**SOUTH DERBYSHIRE DISTRICT COUNCIL’S
ANSWERS TO THE ExA’S THIRD WRITTEN QUESTIONS
FOR DEADLINE 8**

Oaklands Farm Solar Farm NSIP

PINS Reference: EN010122

Figure 1c: Habitat constraints plan

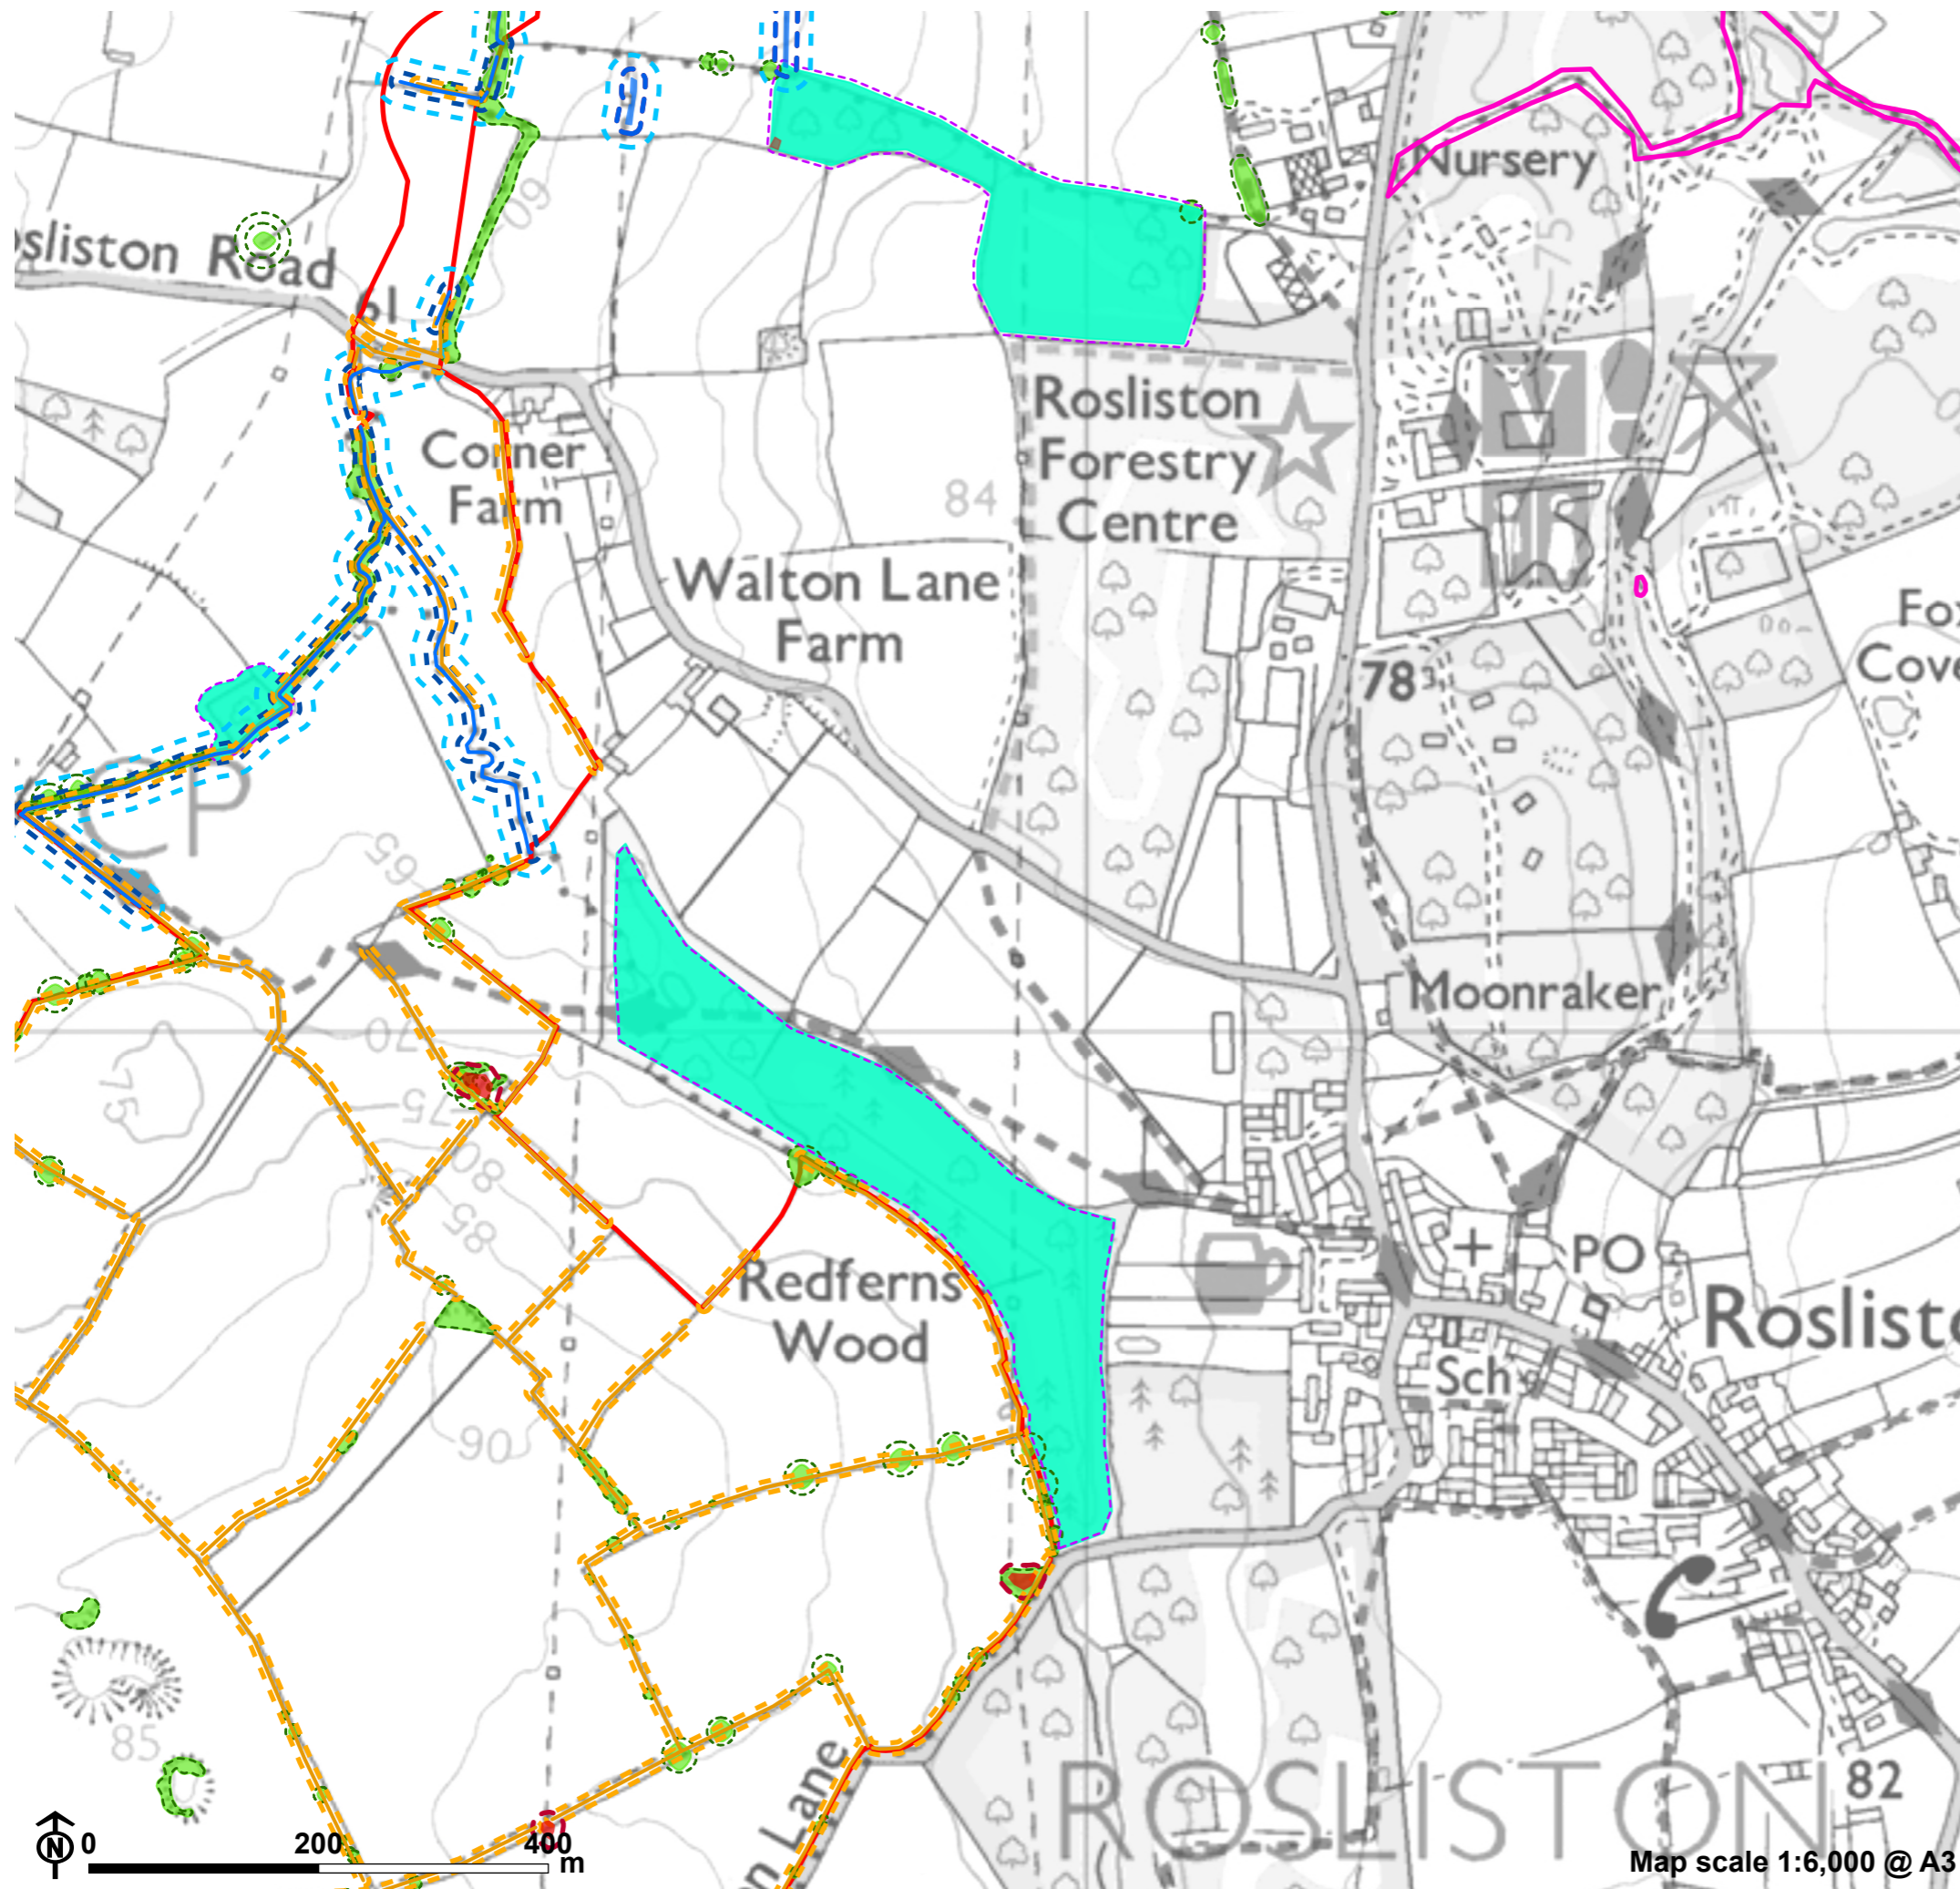
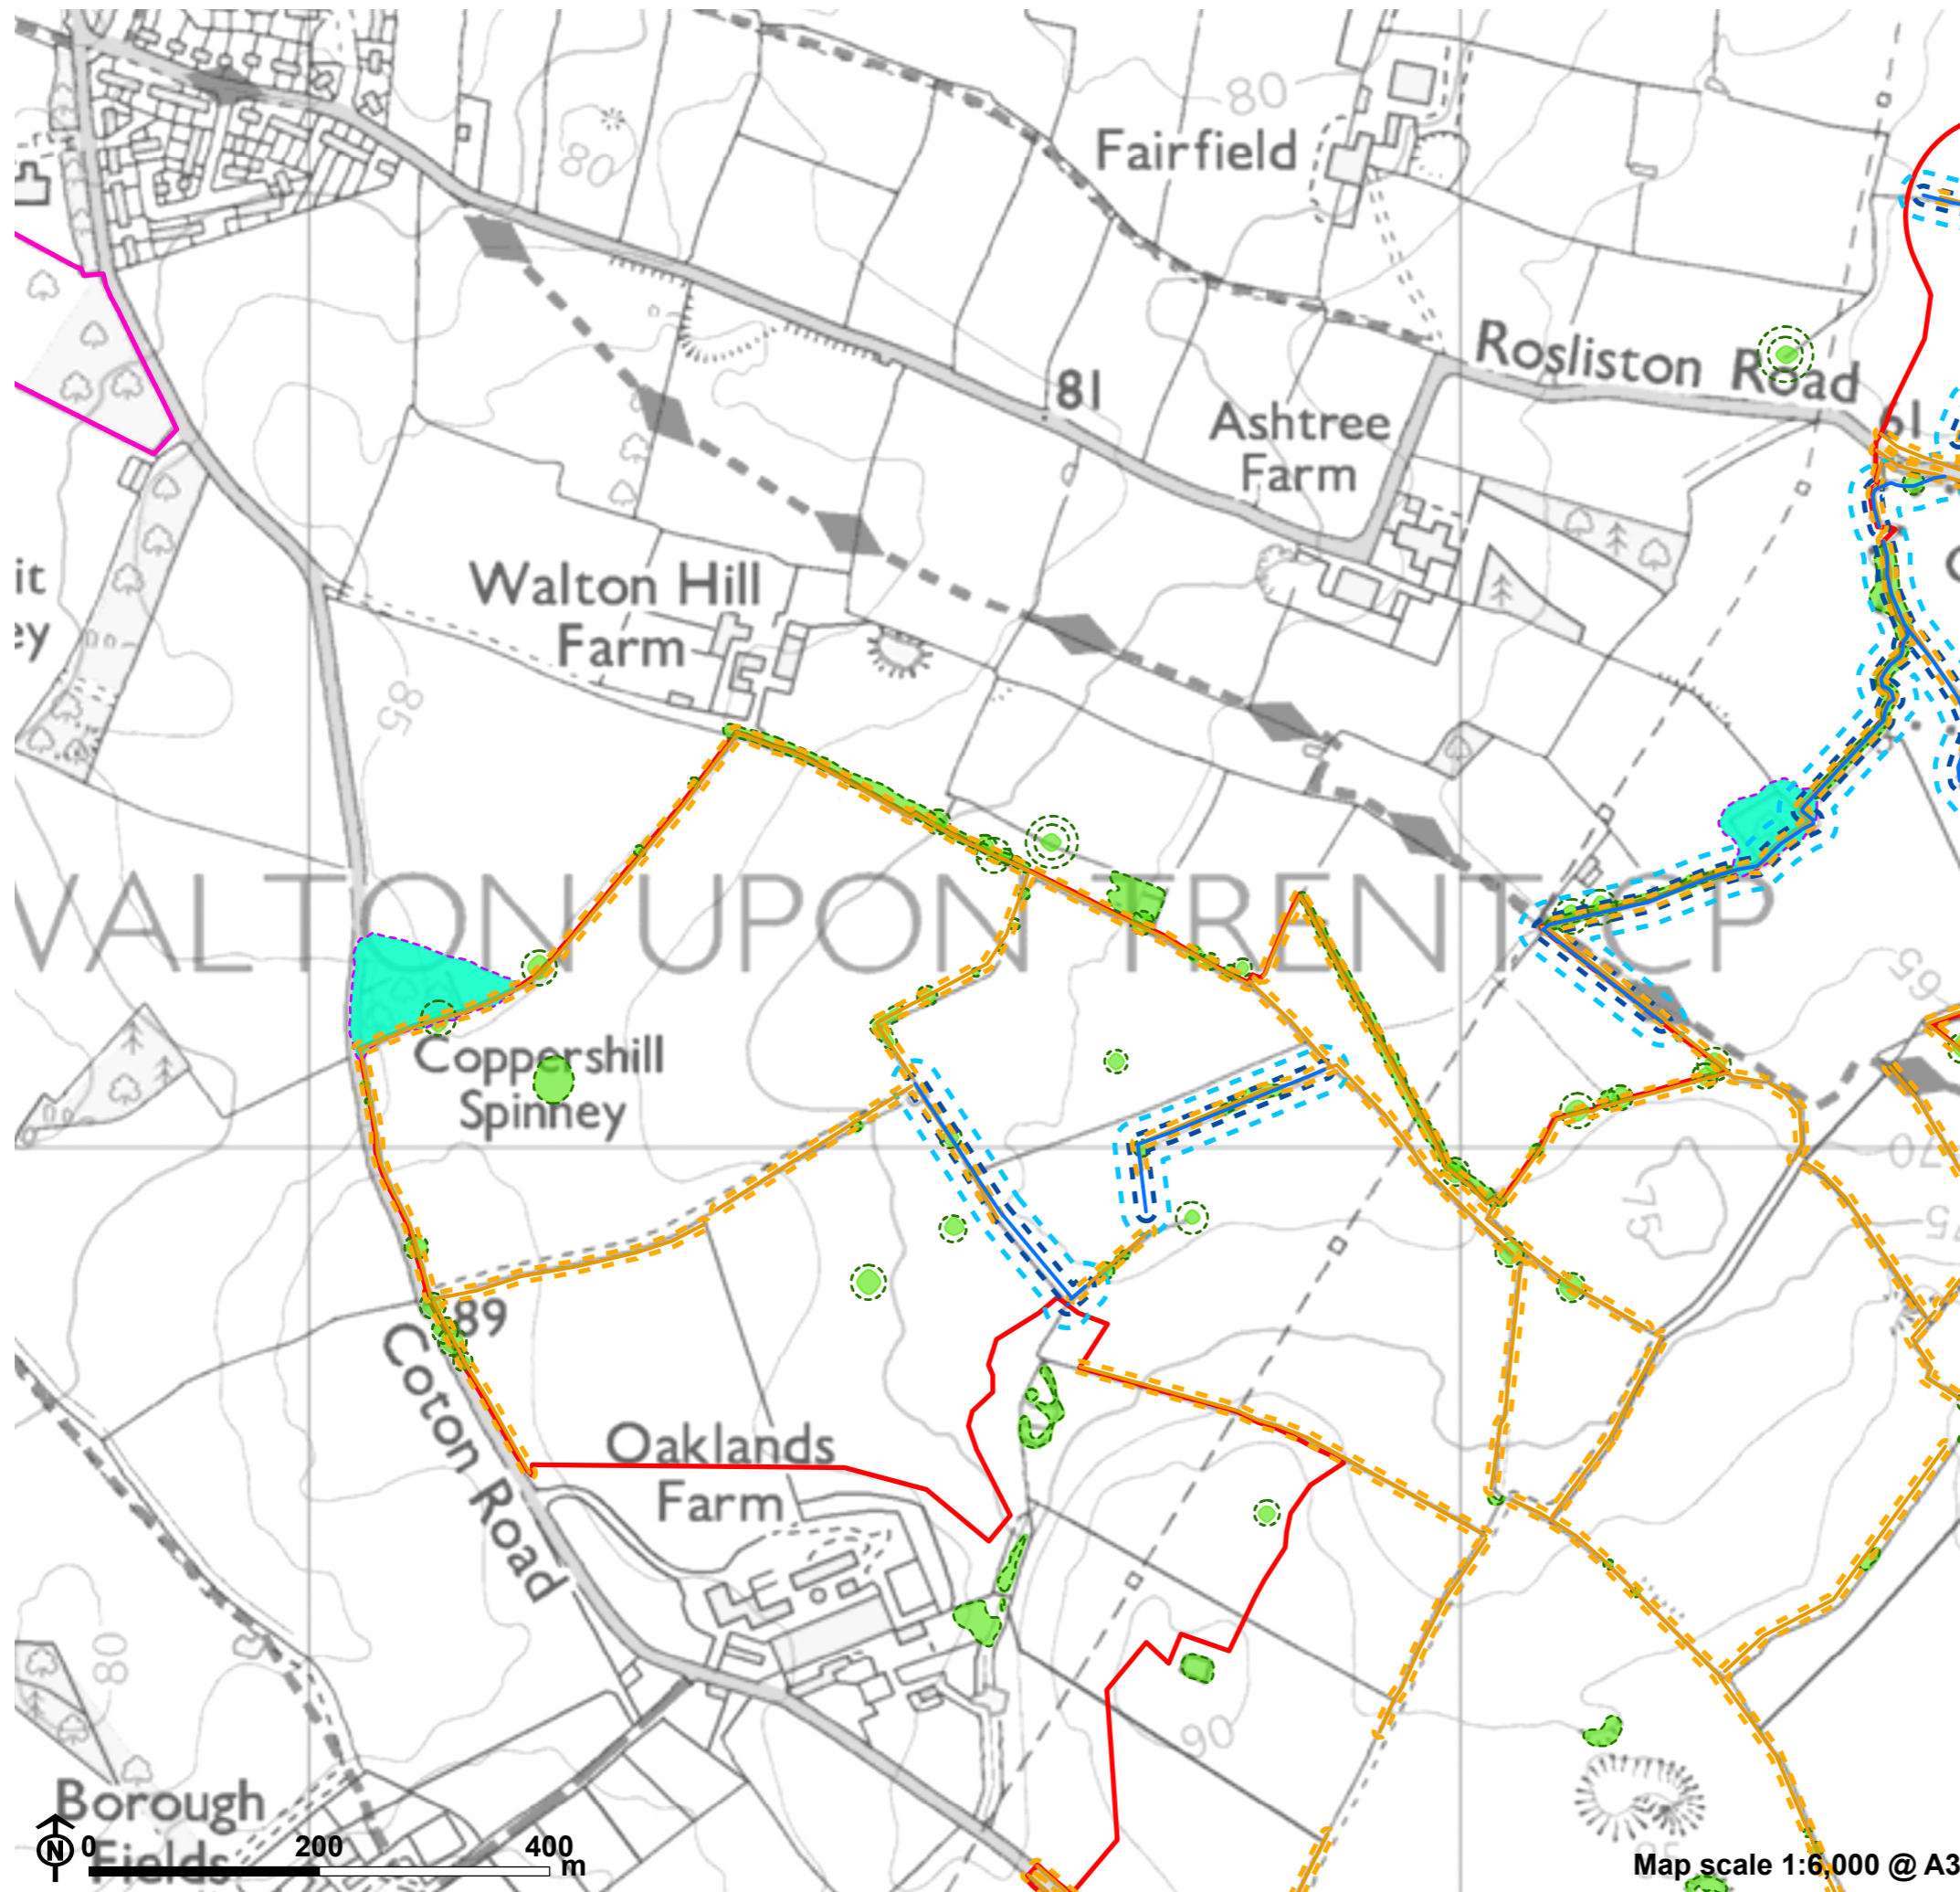
7.3	<p><u>Habitat Constraints Plan</u></p> <p>SDDC [REP4-014] and DCC [REP4-012] referred to the need for a Habitat Constraints Plan with interpretable maps to provide the necessary details and extent of site clearance works relating to buffer zones to sensitive features such as ancient/ veteran trees, other retained trees, ponds, watercourses, hedgerows and woodlands.</p> <p>The Outline CEMP [REP5-011] includes provisions for a Habitats Constraint Plan [Section 2.8.5] and buffers [Sections 2.6.4, 2.6.5, 2.8.2, 2.8.3, 2.8.5, and 2.8.6]. The Applicant provides a series of interpretable maps of habitat constraints [REP5-030].</p> <p>a) Please could the Applicant add the draft interpretable maps to the Outline CEMP [REP5-011] and secure that interpretable maps be included in the final CEMP?</p> <p>b) Please could SDDC and DCC comment?</p>	<p>c) SDDC has no further comments to add in addition to those previously made at Deadline 6, which are repeated below:</p> <p>“SDDC have reviewed those interpretable maps, and they provide useful clarity and should be attached to the Outline CEMP for further comprehensive review.”</p>
